Subject: RE: Y/9818/RES and Y/97/18/DOC

Laura Gibbons, MEng, GMICE
Engineer (Drainage & Coastal)

Comments on the revised drainage and landscape proposals:

Job Title			
LAND SOUTH OF BURNDILL ROAD, YAPTON			
Drawing Title			
PRELIMINARY ENGINEERING LAYOUT			
Client			
BOVIS HOMES			
Scale	Date	Designed	SG
1:500 @A1	NOV 18		
Drawn	Checked	Approved	RS
SOM	LH		
Job No	Drawing No		Rev
18-070	18-070/103		P

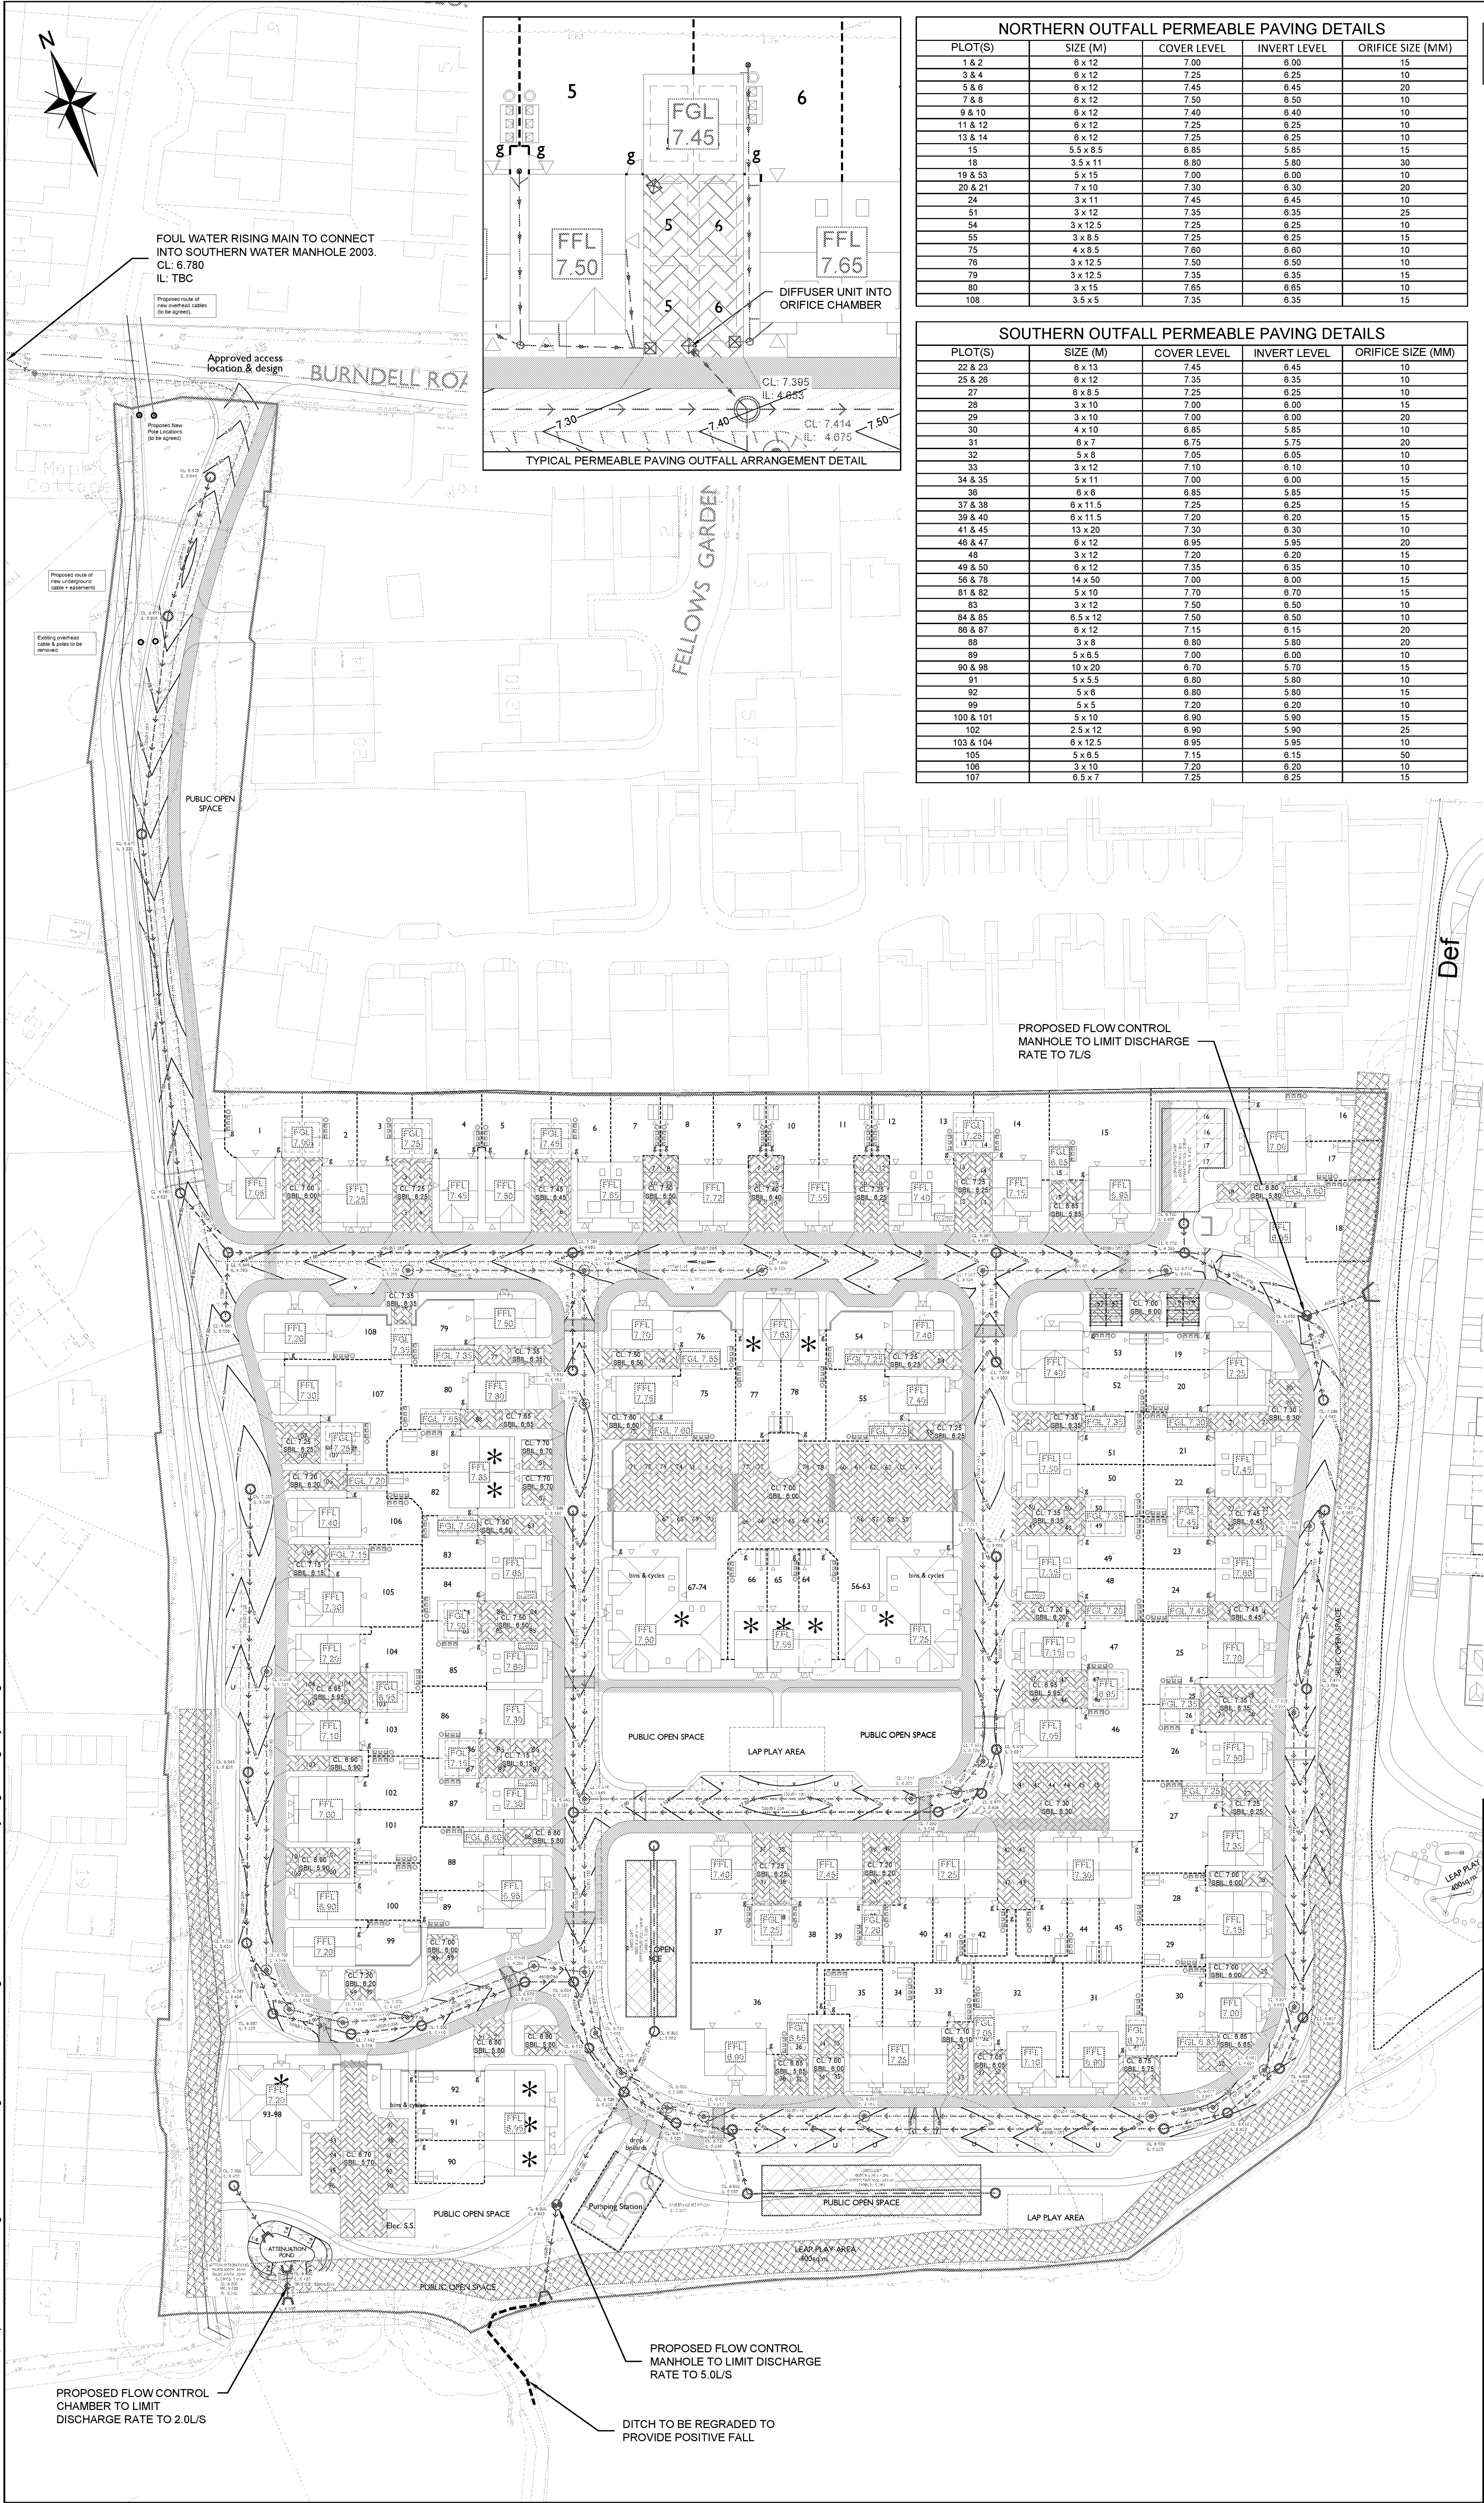
5. Calculations for attenuation basin attached. *Can you provide the full catchment calculations for this?*
6. We are proposing to diffuse rain water from roofs into the permeable paving and then connect the permeable paving to the wider sewer network (via a control). We show this typical arrangement, which applies to every drive, on the top right (inset) of drawing 18-070/103. *What size orifice are you proposing?*

- b. *There are still no drawings or indications on the layout of how the permeable paving connects to the main network. Please provide these. Please also ensure formation and finish levels of permeable paving is provided.*
